Please ask for: Ms Iqraa Malik
Email: iqraa.malik@terraquest.co.uk
Telephone: 01212341390
Our Ref: M/121/21/HH
Your Ref:
Date: 25th August 2021

Application for Planning Permission for Works or Extension to a Dwelling

Development: Retention of two storey rear extension, conversion of garage to habitable use, 3 x side dormers and 1 x rear dormer with balcony
Location: Driftwood Manor Way Elmer Middleton-On-Sea PO22 6LA

Pre-existing Plans & Elevations

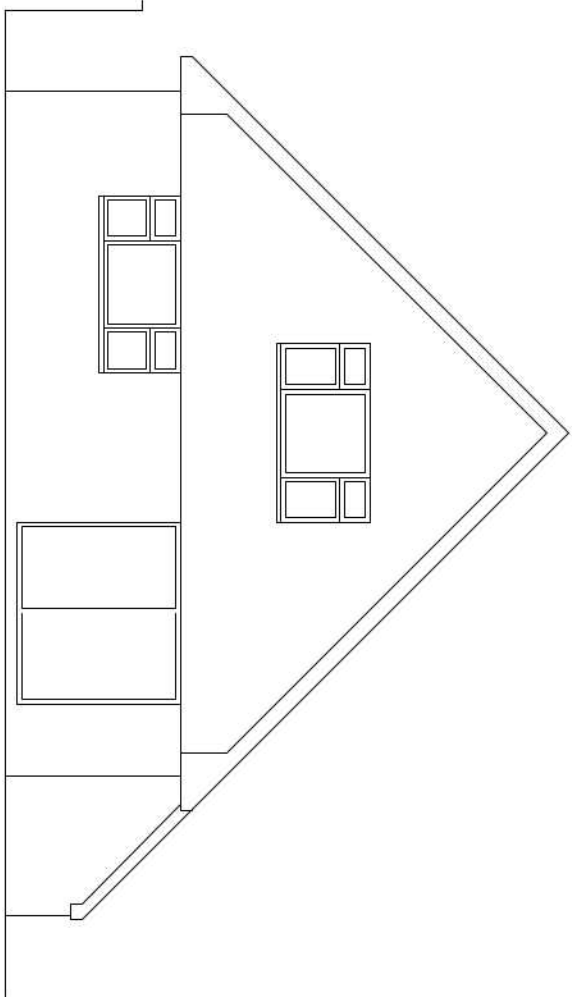
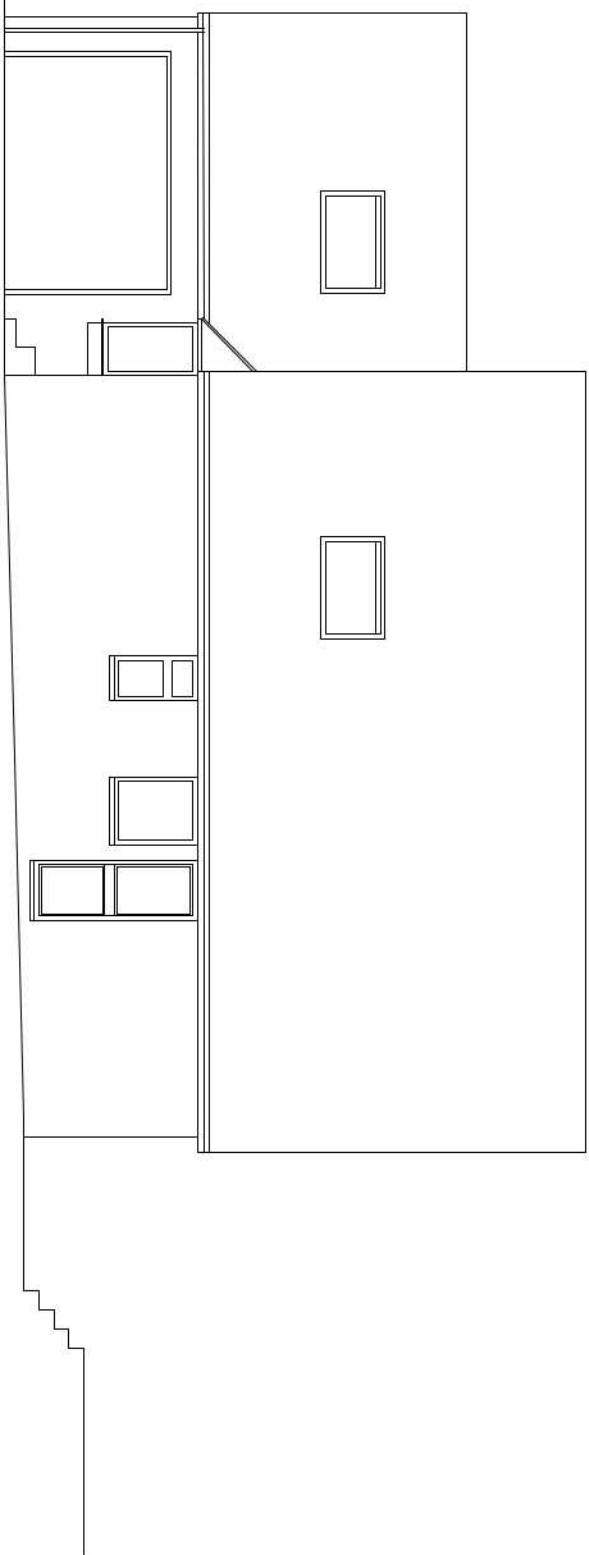
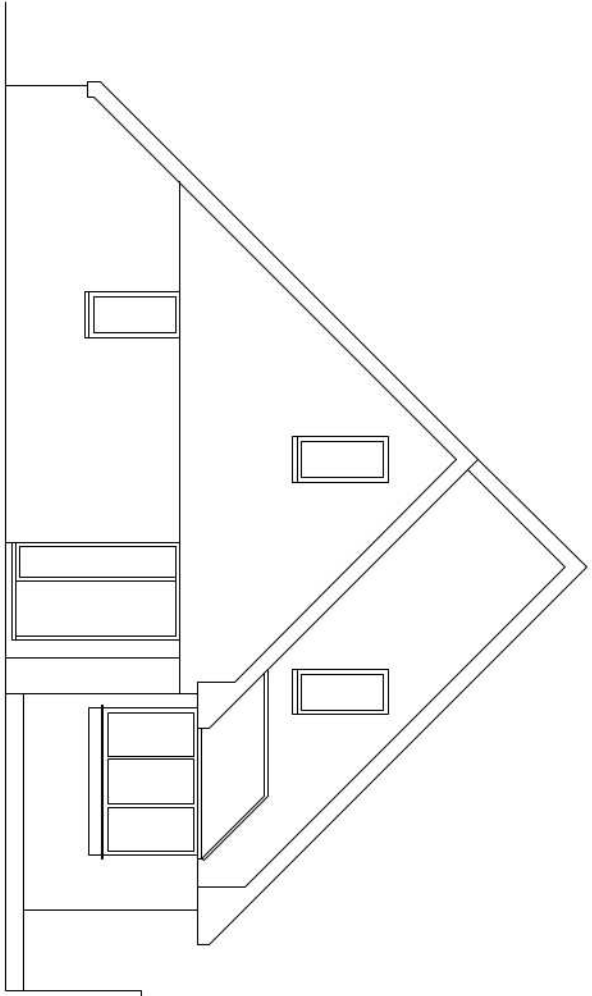
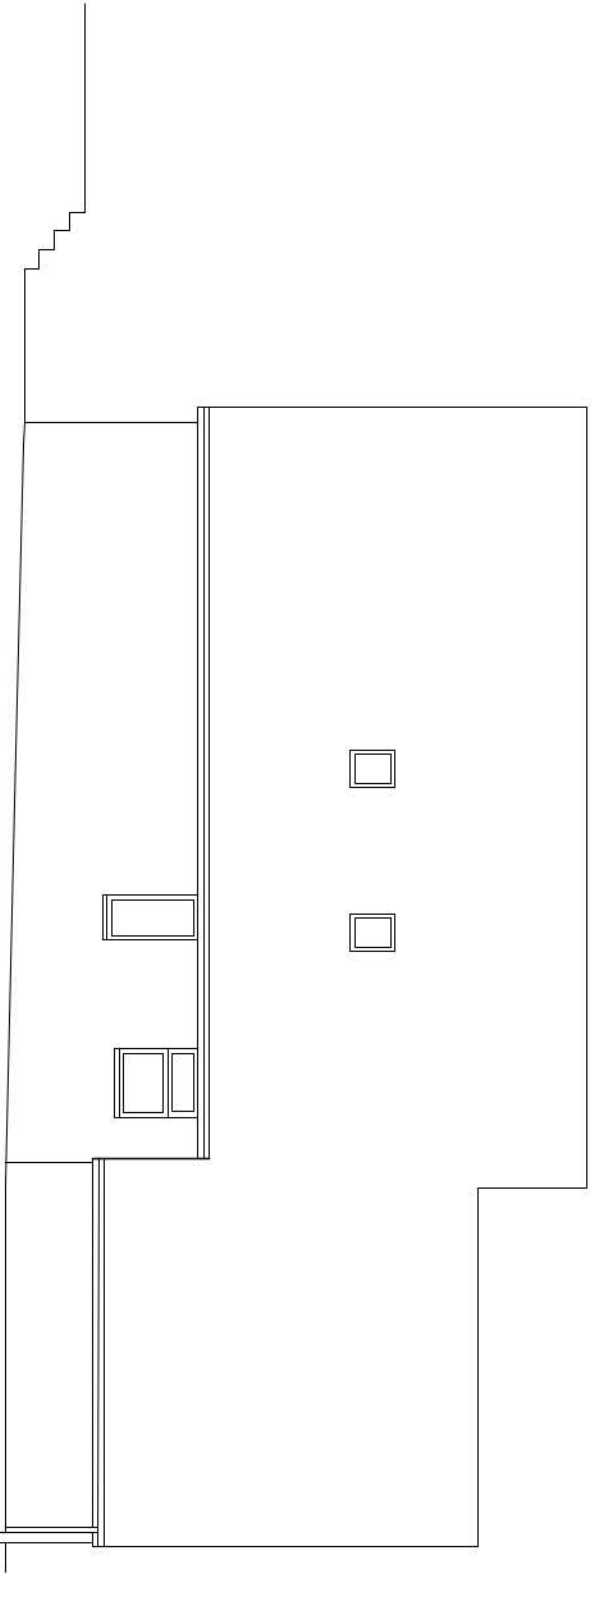
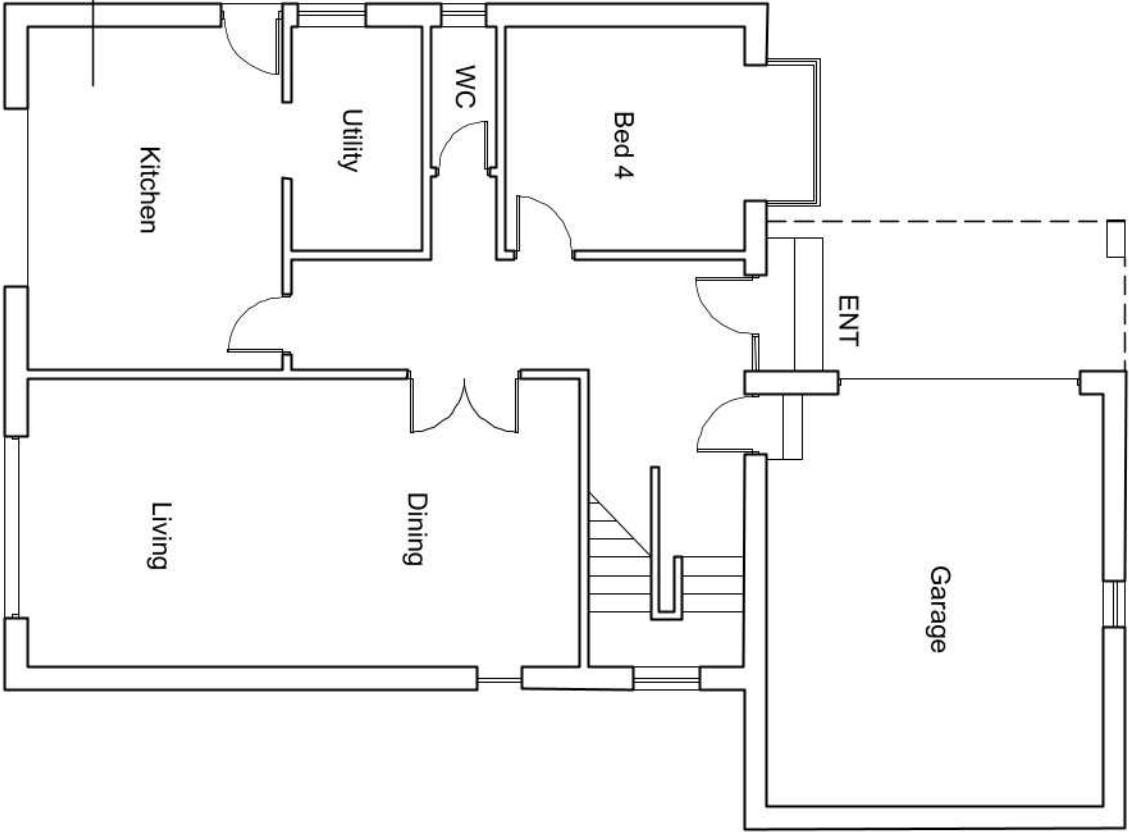
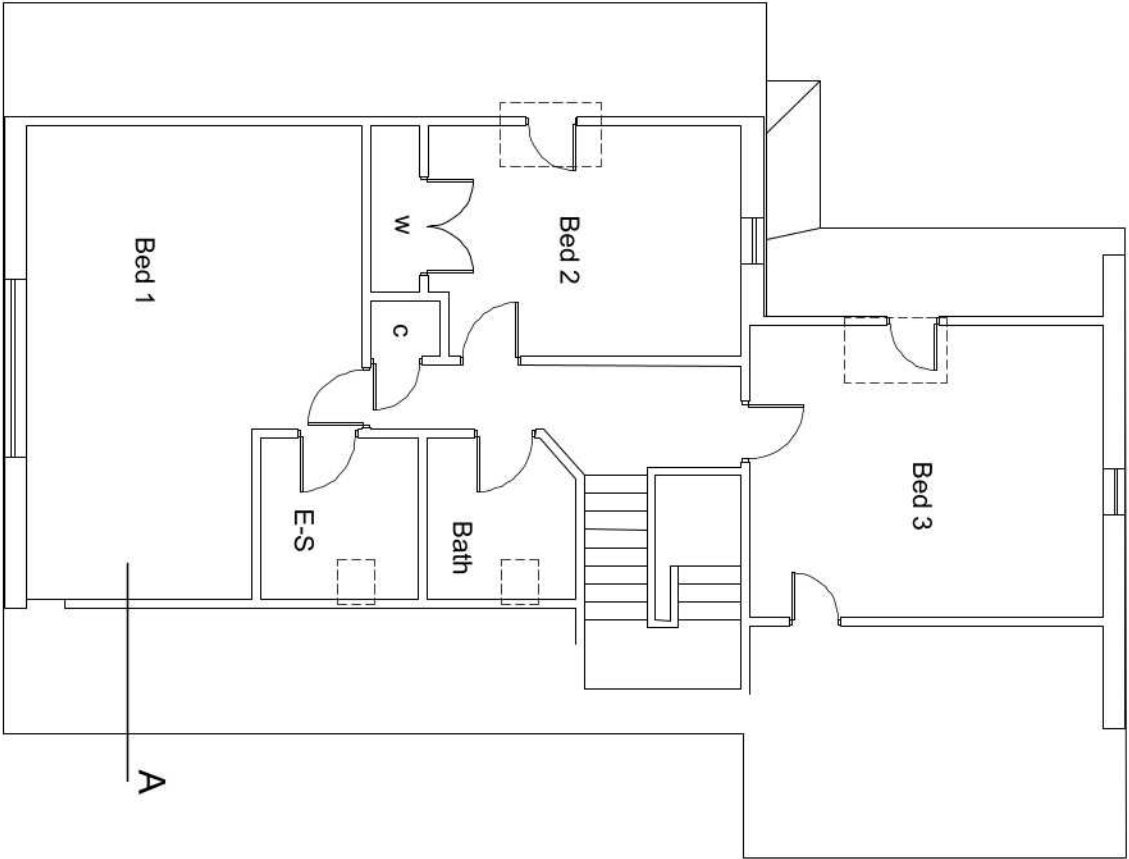
The garage window measures inconsistently between the Existing and Proposed Plans

The windows are inconsistent between the existing first floor and existing west/east elevations. Along with this, they are also inconsistent between the proposed first floor plan and the proposed west elevation. Please review and amend.

As the works have already been completed, please amend labels of the existing plans to 'pre-existing' and proposed plans to 'existing'.

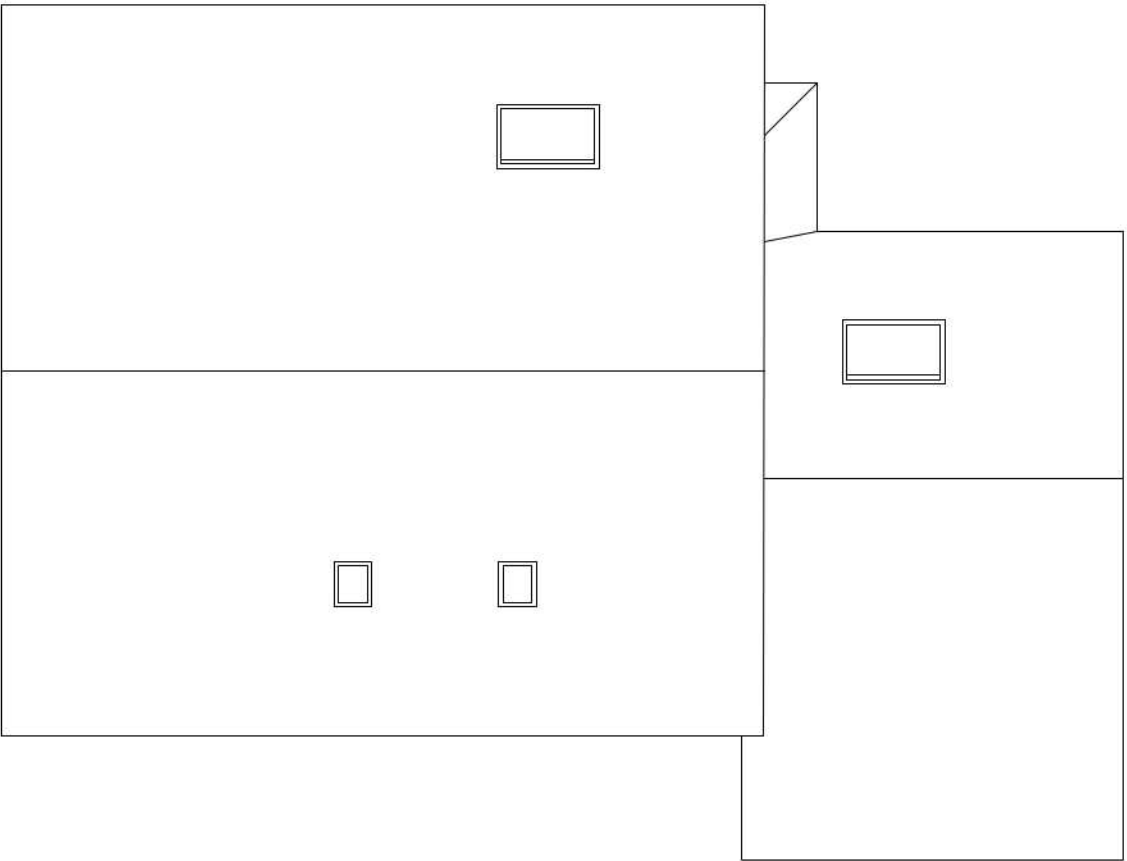
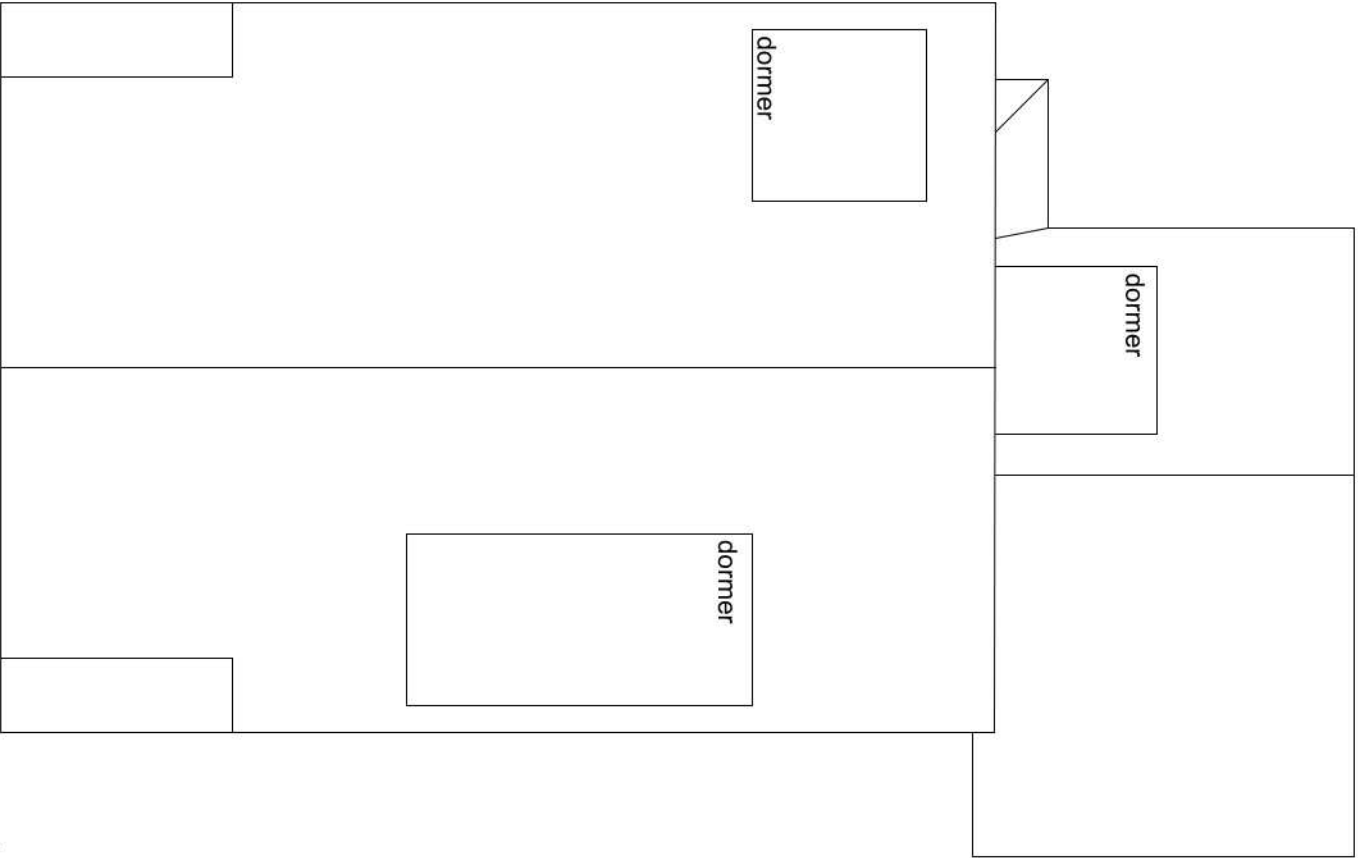
Please submit 1 electronic or 3 paper copies of existing and proposed roof plan. Please refer to the Validation Requirements List for further details.
